Your ref:  
Our ref: 22/00750/F  
Please ask for: Mrs Joanne Rahman  
Direct dial: 01553 616233  
E-mail: borough.planning@west-norfolk.gov.uk

Details: **Installation of 1no Solar Tracker Array at 11A Lime Kiln Road Gayton Norfolk PE32 1QT**

Pcs: 1	Part Name: PV-6M Morning Position	Material:
Designer: Mike	Assembly Name: Dimensions	Scale: 1:16 View:  
 <b>HelioZenit</b> <a href="mailto:info@heliomotion.com">info@heliomotion.com</a>	<b>Heliomotion</b>	Version: 1a
		Part Number:

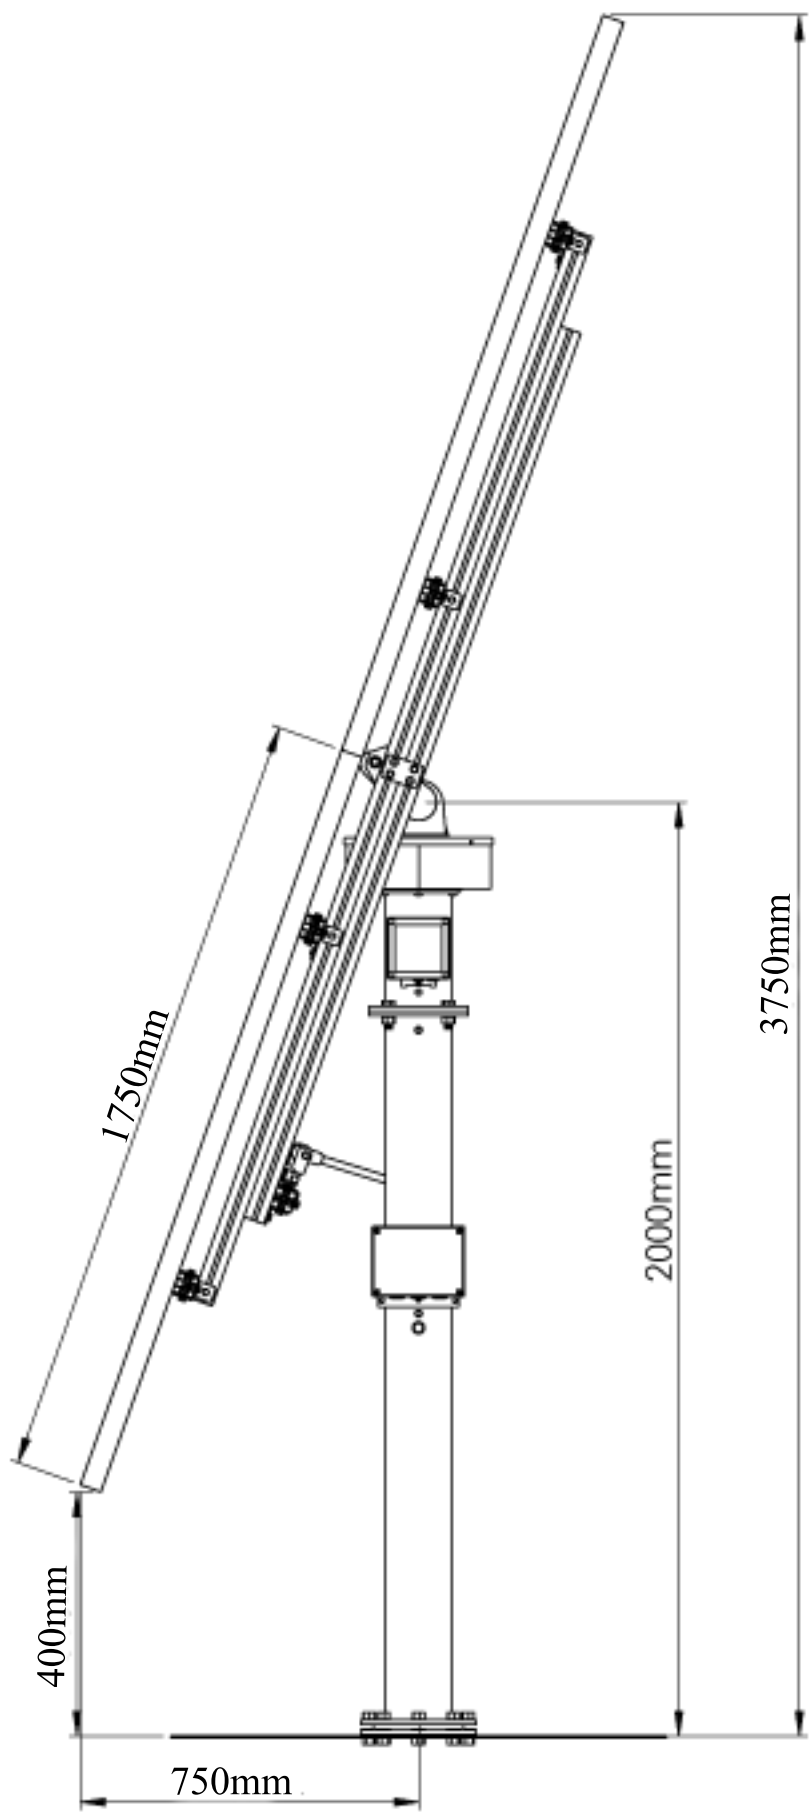
1. Thank you for providing elevations but these should be done to a recognisable scale and be measured easily using a scale rule. Please resubmit these plans done to a recognisable scale such as 1:20 or 1:50.
